Planning Consultation Memo

Date: 14 November 2019	Planning Officer: David Elmore	Landscape/Tree Officer: Oliver Waring
Planning Application Number	<u>6/2019/2557/COND</u>	
	<u>2 (Tree protection plan) and 4 Hard and soft landscaping</u>

Context	
Site Address	Sparrow Farm, Newgate Street Village, Hertford, SG13 8QR
Relevant Constraints/Policies	<p>WHDP 2005</p> <p>R11 – Biodiversity and Development – all new development will be required to demonstrate how it would contribute positively to biodiversity of the site by retention and enhancement of the natural features on site.</p> <p>R17 – Trees, woodland and hedgerows – the council will seek the protection and retention of these features and require when appropriate new, native planting.</p> <p>D8 – Landscaping – the council will require the retention and enhancement of existing key landscape features (requiring detailed surveys)</p> <p>Policies from the Draft local plan -</p> <p>SP11 – Protection and enhancement of critical environmental assets – protection, enhancement and management of the environmental, ecological and historical assets within the borough, will be sought commensurate with their status, significance and internatio

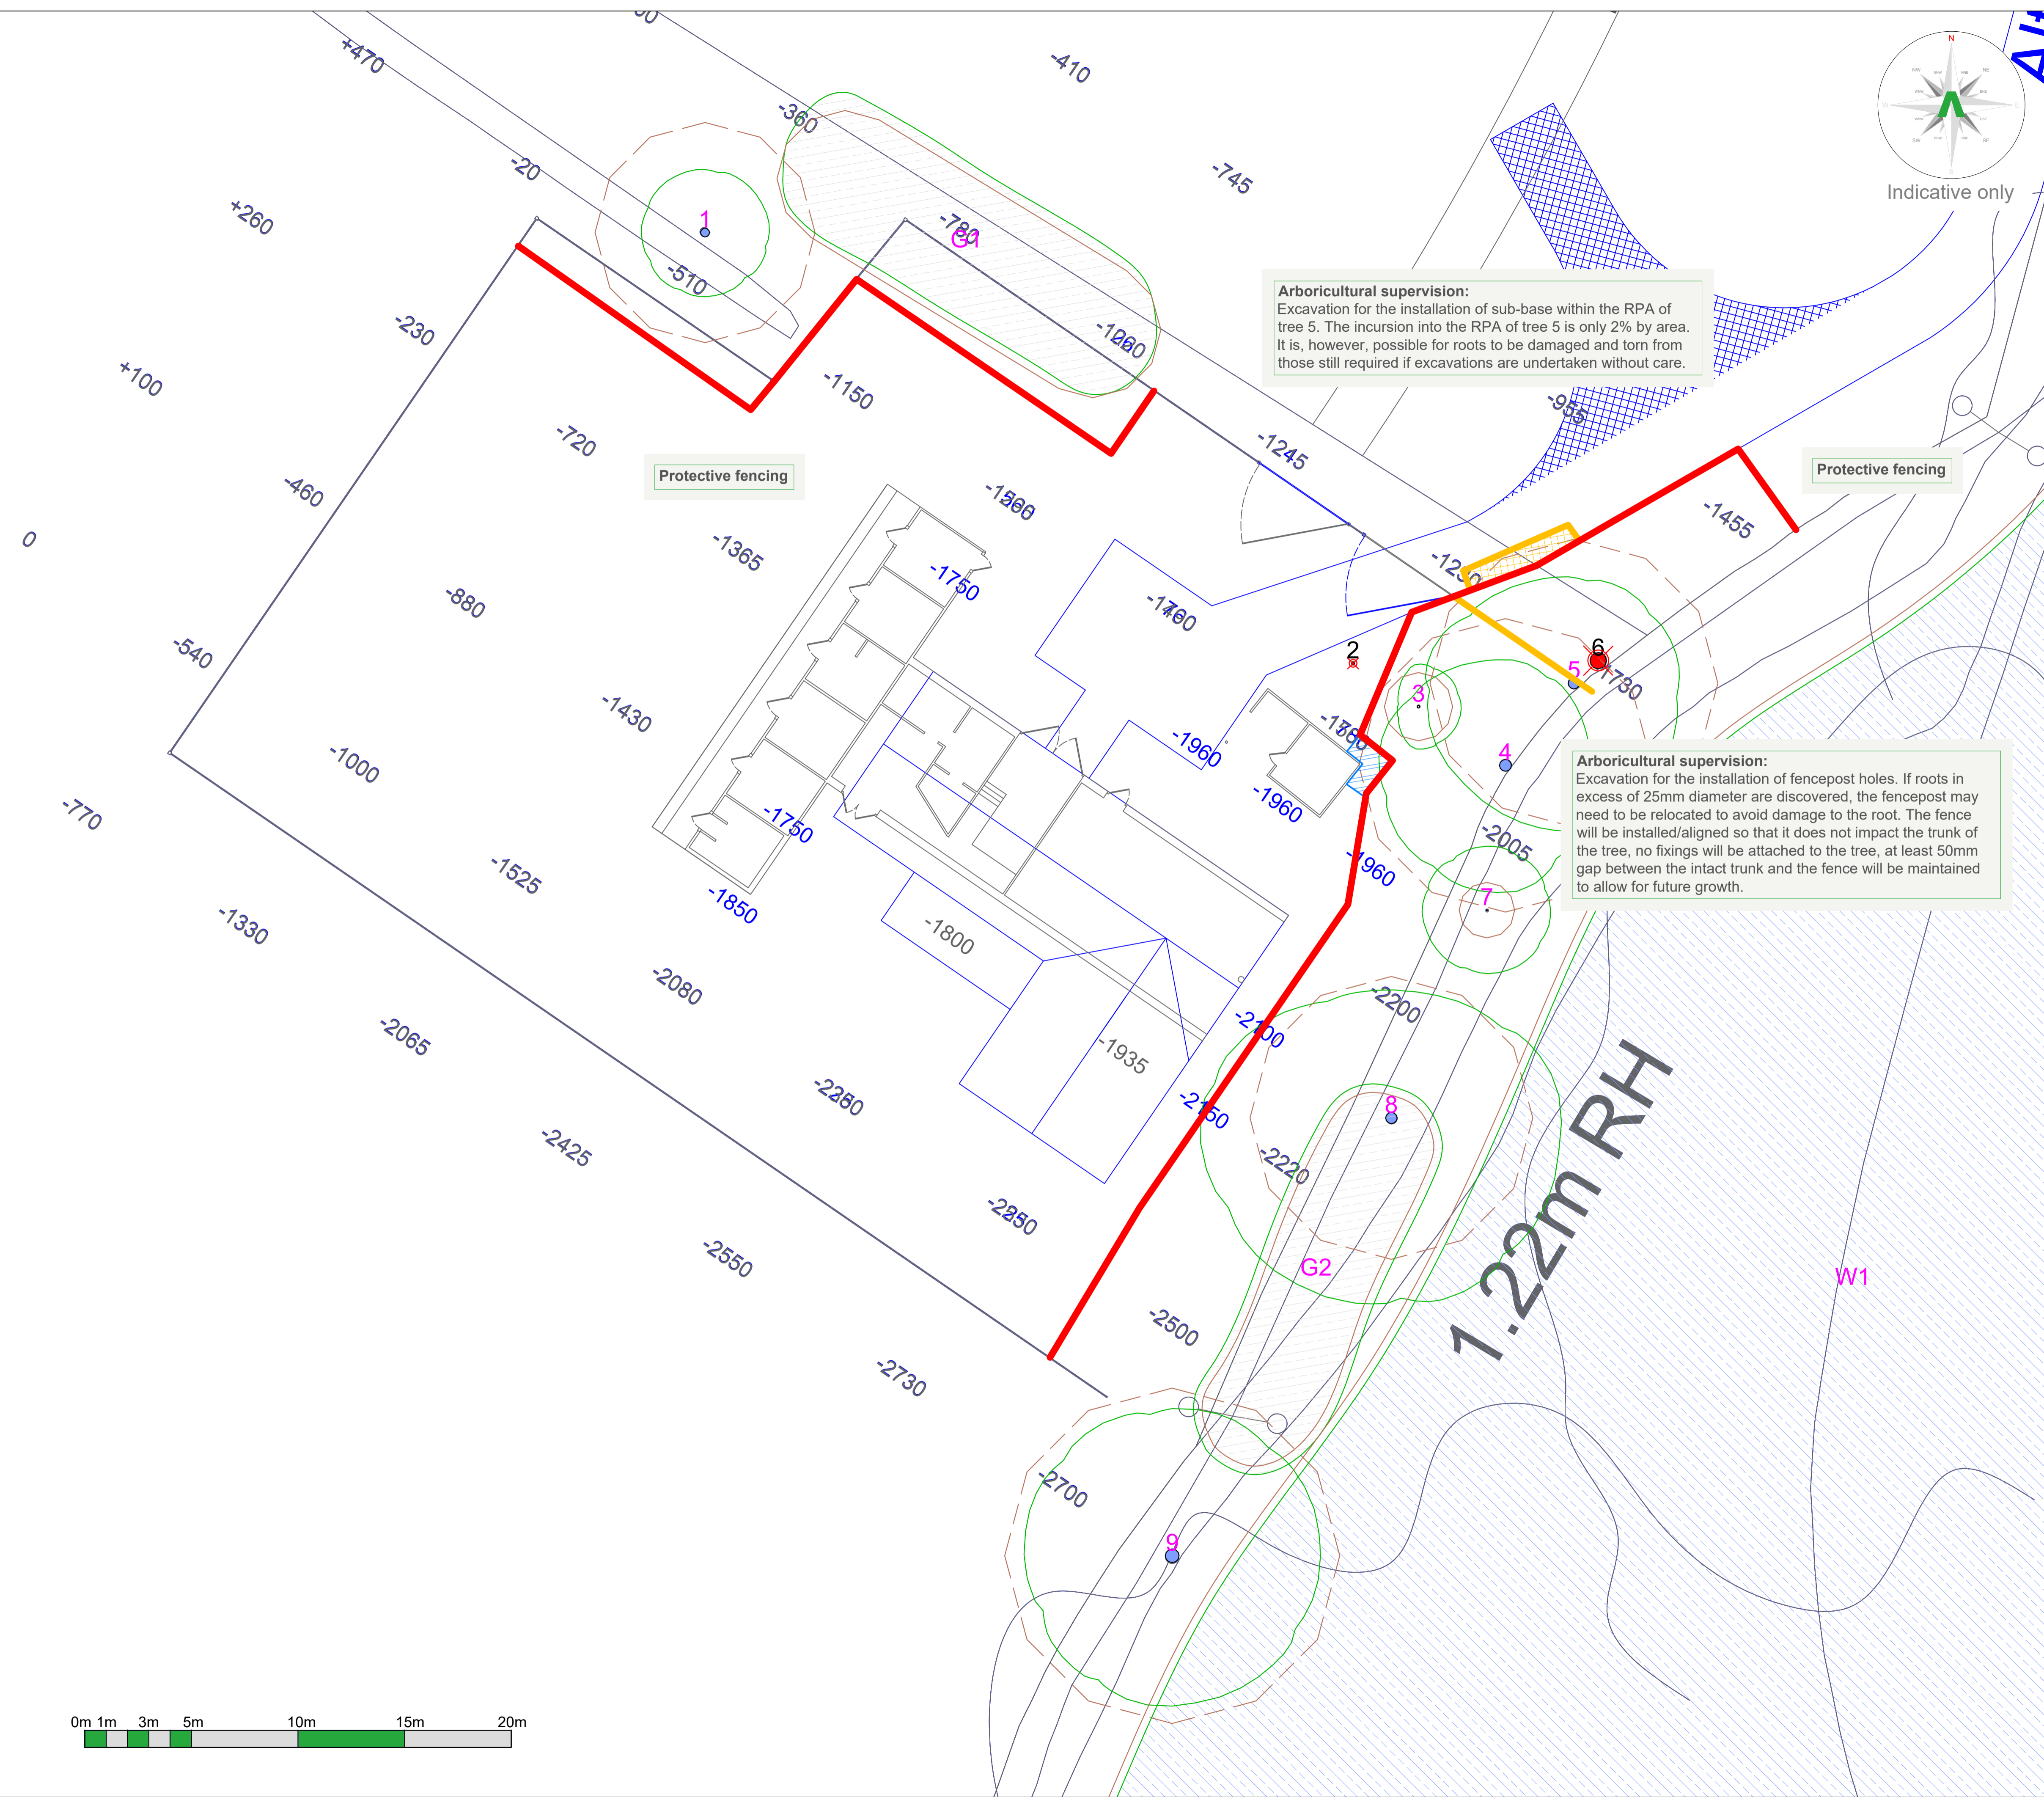
<p>Has any BS: 5837:2012 information been supplied?</p> <p><input checked="" type="checkbox"/> Yes <input type="checkbox"/> No <input type="checkbox"/> N/A</p> <p>Comment: An Arb report has been supplied which includes a tree protection plan. The protection is considered sufficient to discharge the condition.</p>
<p>Would the development maintain the amenity of adjoining occupiers? (e.g. privacy, outlook, light etc.)</p> <p><input checked="" type="checkbox"/> Yes <input type="checkbox"/> No</p> <p>Comment (if applicable):</p>
<p>Is there a detailed proposed landscape plan?</p> <p><input checked="" type="checkbox"/> Yes <input type="checkbox"/> No <input type="checkbox"/> N/A</p> <p>Comment (if applicable): Some landscape detail has been supplied via a landscape plan. The proposed hedging is appropriate as are the plant sizes and spacings.</p> <p>The plan shows proposed tree planting. Generally the species choice is appropriate however it does mention planting ash trees. Ash should not be planted due to ash die-back and I recommend that this is swapped for hornbeam. It would also be useful to know the size of the trees being planted.</p>

<p>Recommendations and conclusion</p> <p>The proposed tree protection is appropriate and sufficient to discharge the condition.</p> <p>There are some minor details regarding the landscape proposes need to be clarified (see above) before the condition can be discharged.</p>
